## Submissions and Amendment Report

SSD 9835 – Sydney Football Stadium Stage 2

Modification 7 – Precinct Village and Car Park

17 December 2021 | 2210490

Tennis building

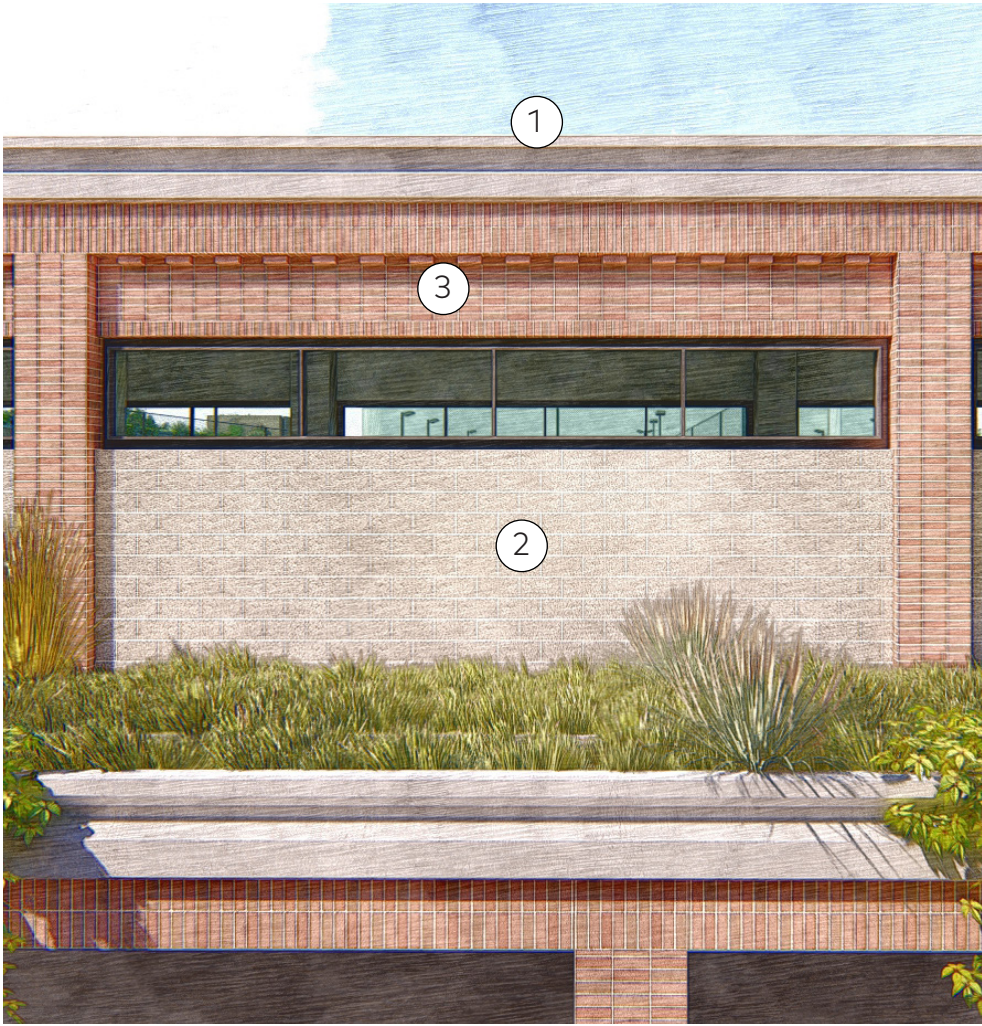
- Replacement of the previously proposed stepping in the tennis club’s brick clad fascia between columns with polished blockwork that is consistent with materials used in the stadium.

- Replacement of the previously proposed green planted edge roof on the tennis club with pebbles in an artistic pattern.
- Raising of the plaza level on the eastern concourse to accommodate existing underground services and maintaining the head height for outside broadcasting compound area, while separating ramps for pedestrians and vehicles with different gradients to maintain DDA compliance.
